EL PASO COUNTY
STORMWATER MANAGEMENT PLAN CHECKLIST
The Sanctuary Filing 1 at Meridian Ranch

EGP-22-002

EPC Project Number: SF-22XXX **SF-22-020**

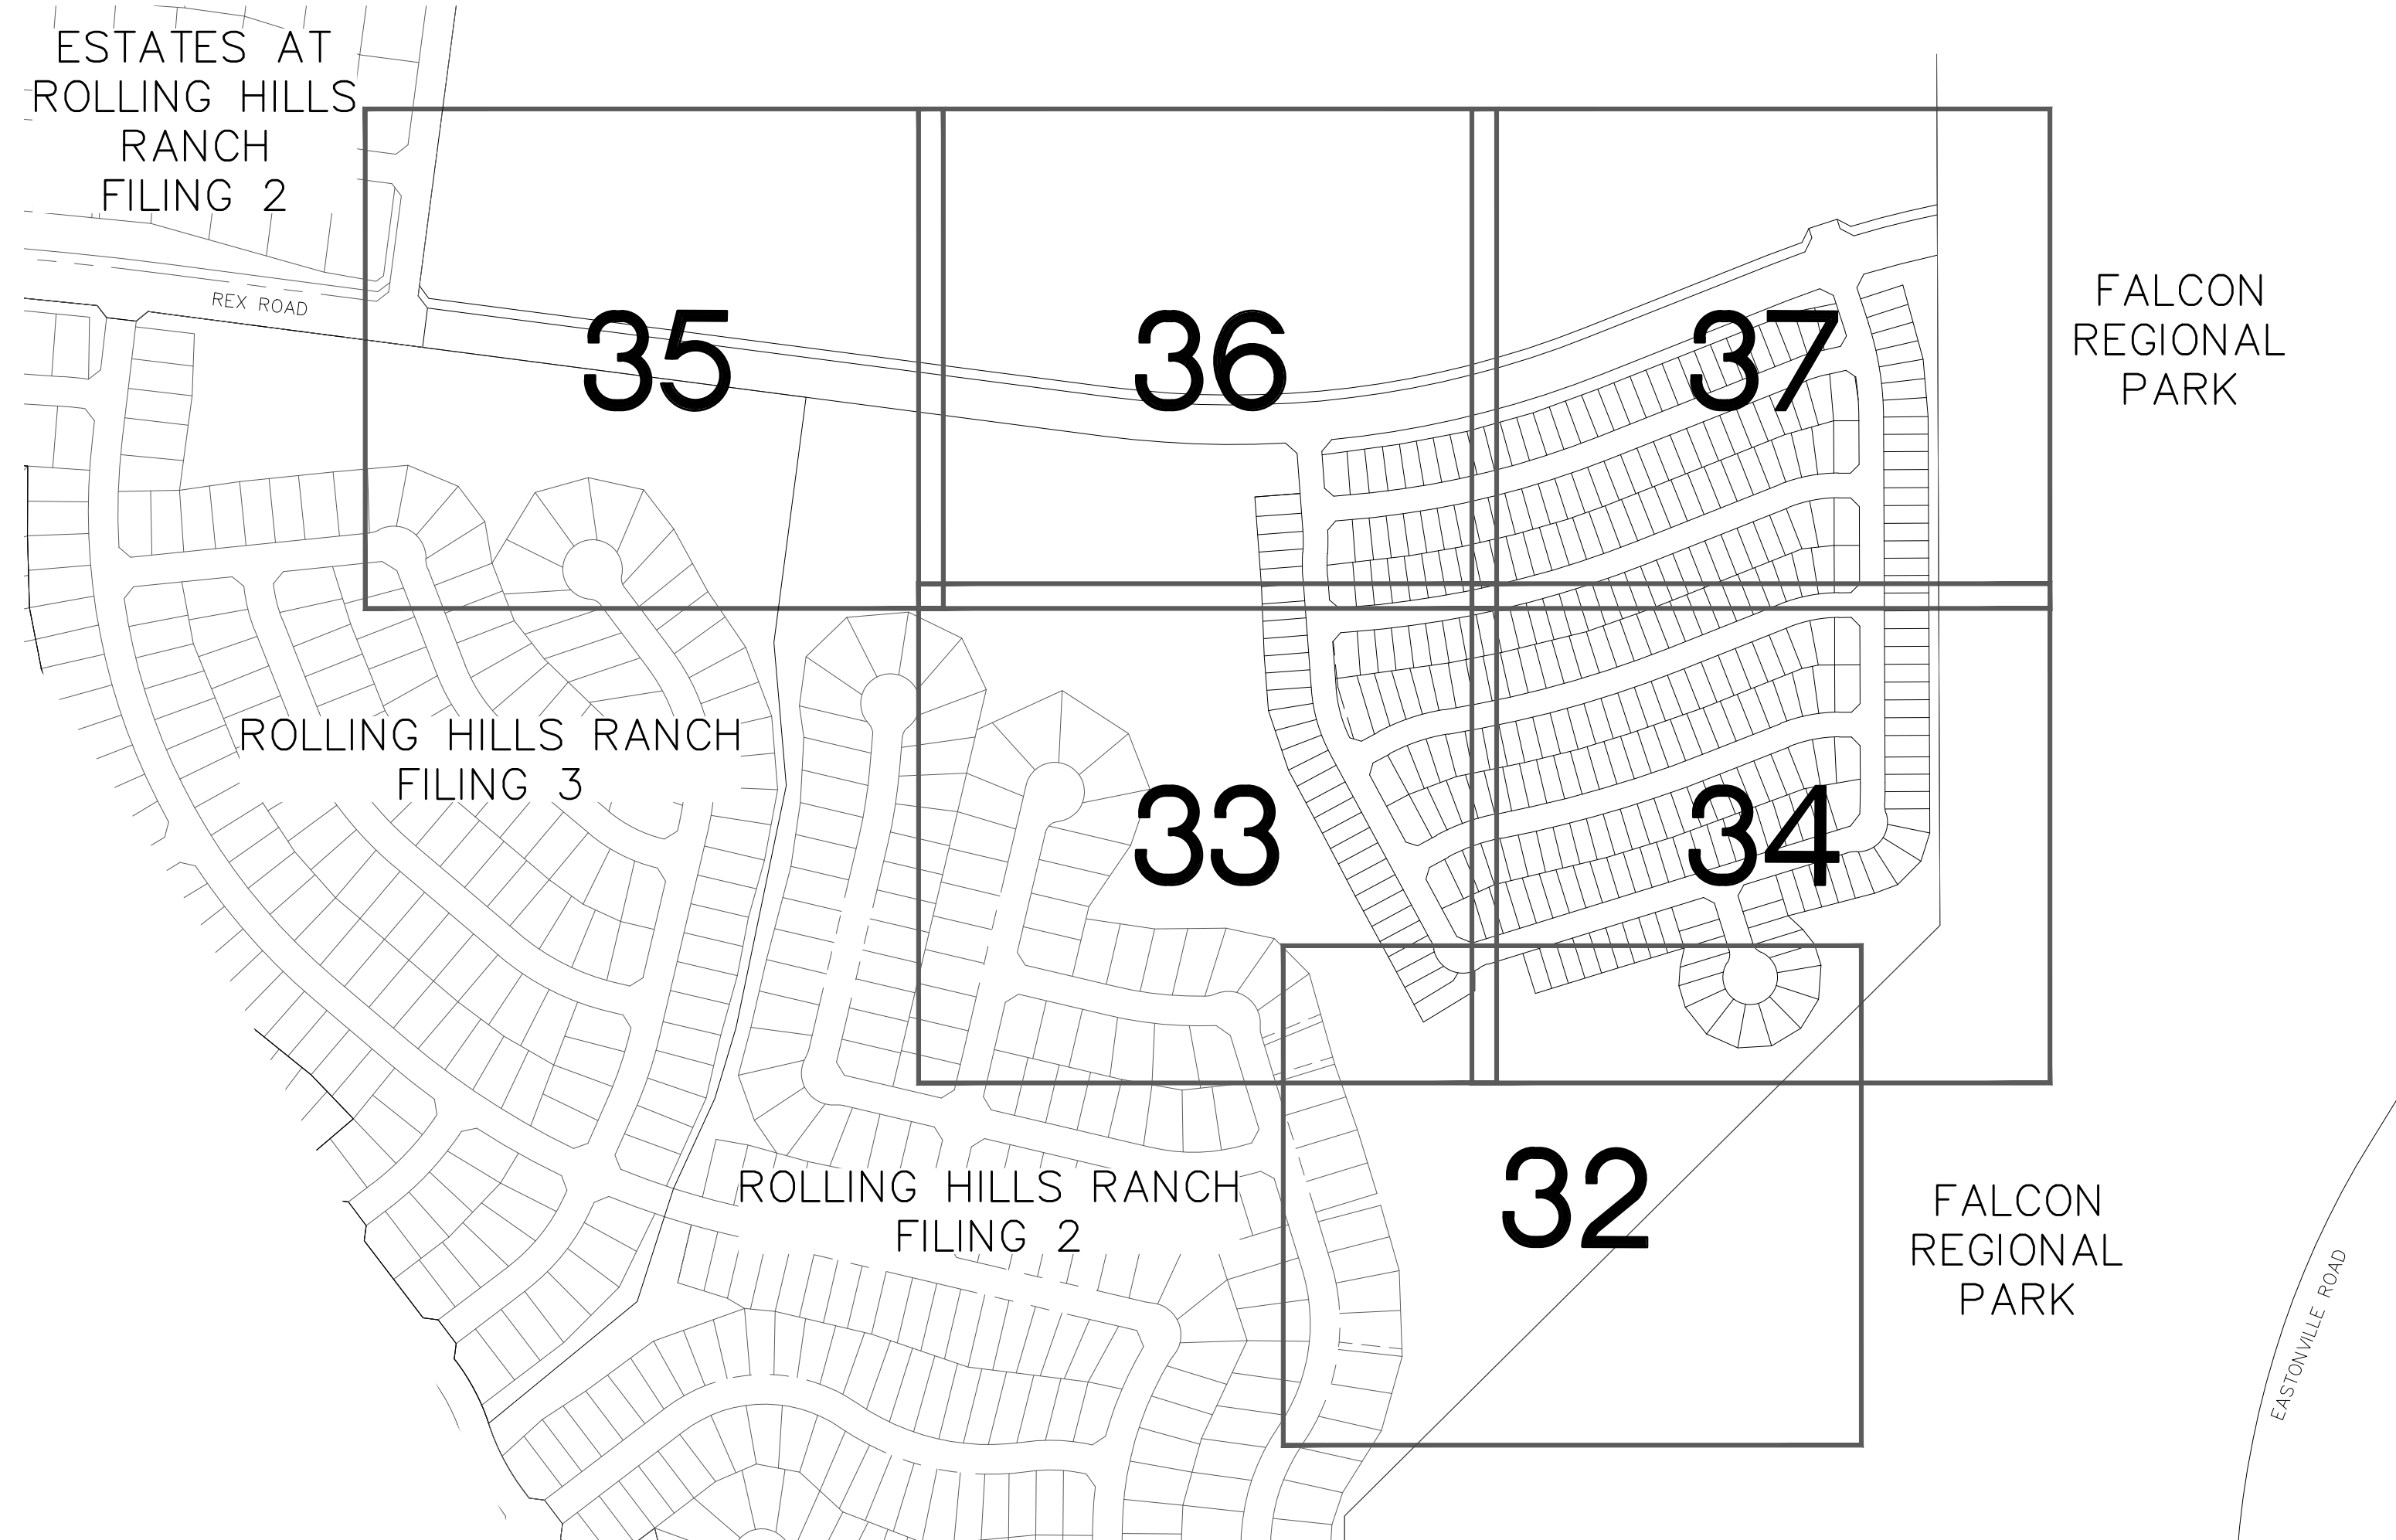
Applicant	EPC
17	SWMP Map to include: Reviewed CDs_v1		
17a	construction site boundaries	X	X
17b	flow arrows to depict stormwater flow directions	X	X
17c	all areas of disturbance	X	X
17d	areas of cut and fill	X	✓
17e	areas used for storage of building materials, Note #2, sheet 31 astes	X	X
17f	location of any dedicated asphalt / concrete Note #3, sheet 31	X	✓
17g	location of all structural control measures	X	X
17h	location of all non-structural control measures	X	X
17i	springs, streams, wetlands and other surface waters, including areas that require maintenance of pre-existing vegetation within 50 feet of a receiving water	X	✓
18	Narrative description of all structural control measures to be used. Modifications to EPC standard control measures must meet or exceed County-approved details	X	✓
19	Description of all non-structural control measures to be used including seeding, mulching, protection of existing vegetation, site watering, sod placement, etc.	X	✓
